Our ref: R/267/10/NMA

23 December 2010

Application for a non-material amendment following a grant of planning permission R/36/10 – Change to gable wall elevation of unit 9 from face brick to render and amendments to unit 10. The Fletcher Arms, Station Road, Rustington.

5434 L(04)001 E

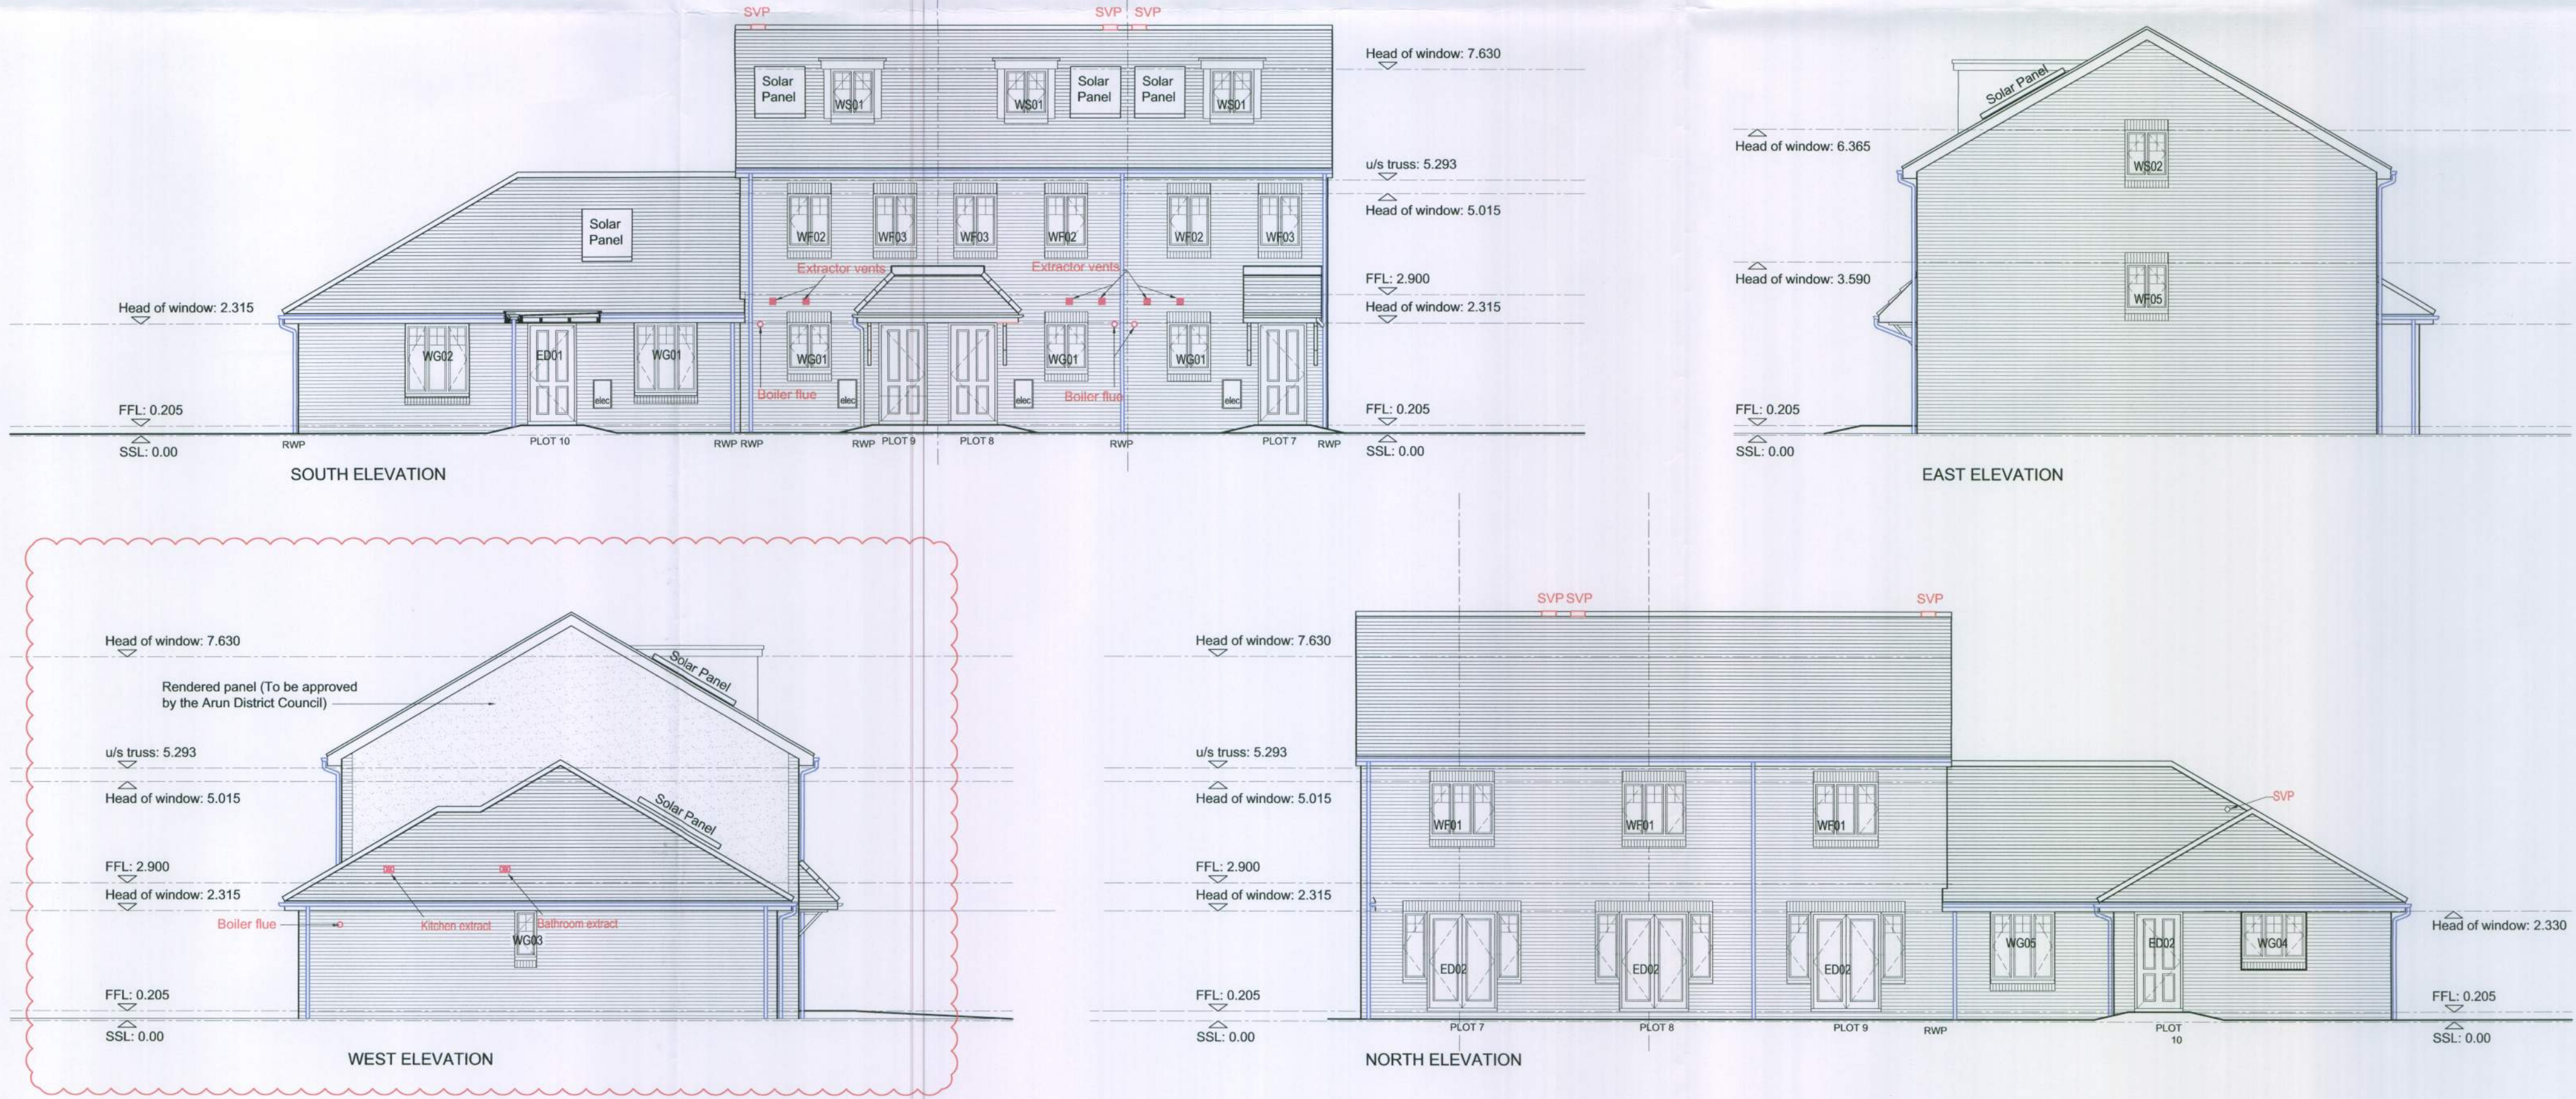
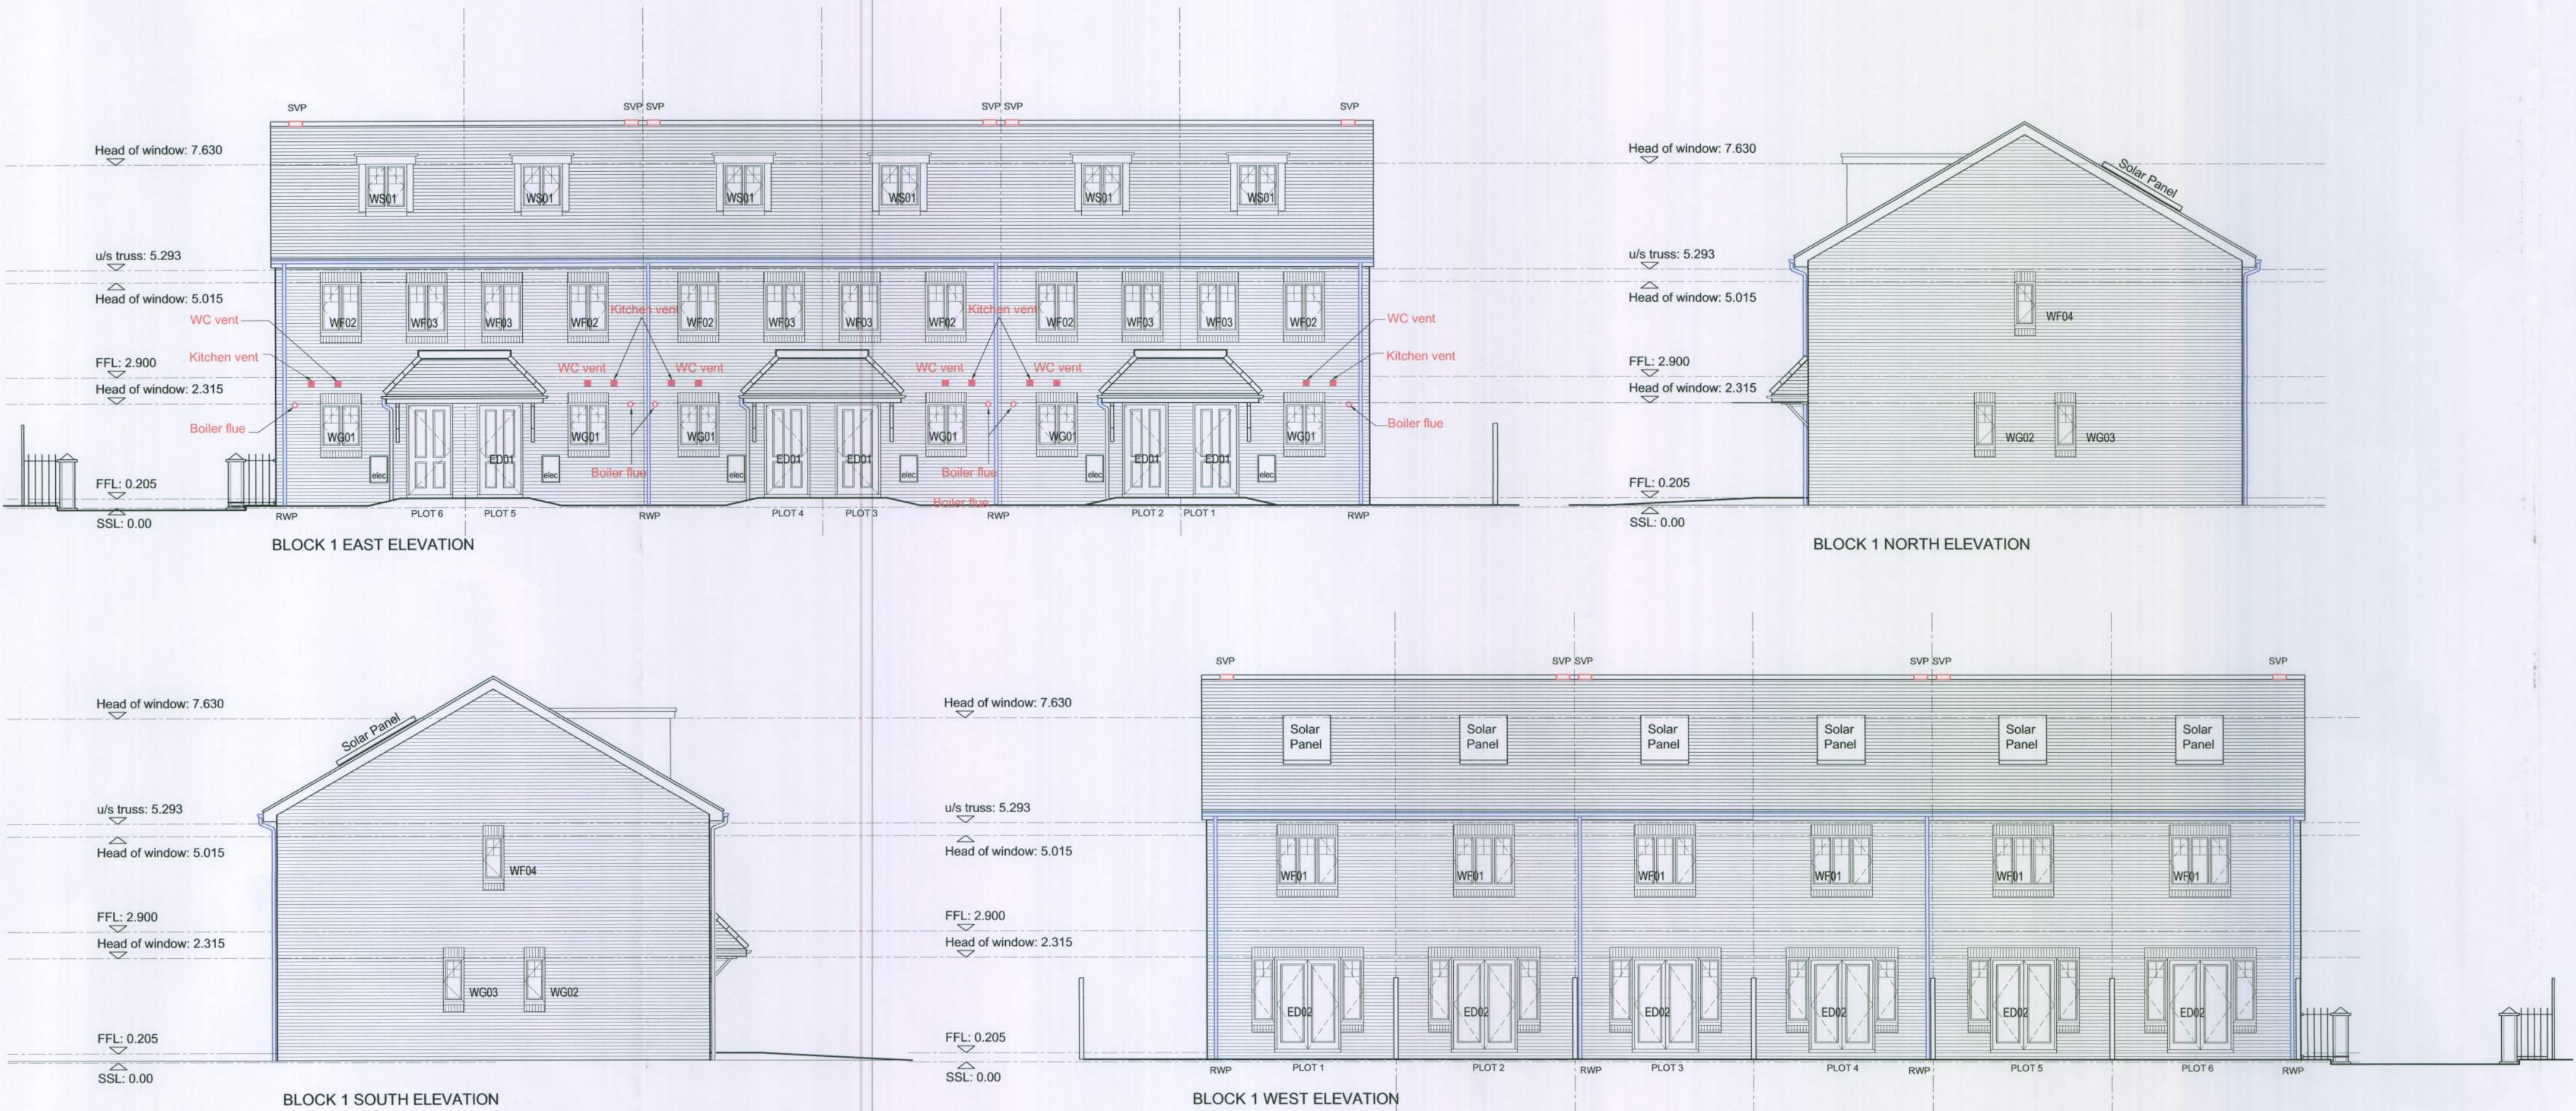
The changes that are identified on your submitted plan, Drawing No. L(04)001 Rev E, from the approved plan, namely the change of materials of the end elevation of unit 9 from face brick to render together with the change of footprint of unit 10 to accommodate internal disabled access, will be acceptable as Non Material Amendment.

Please note that the submitted plans therefore become the approved plans for planning application R/36/10.
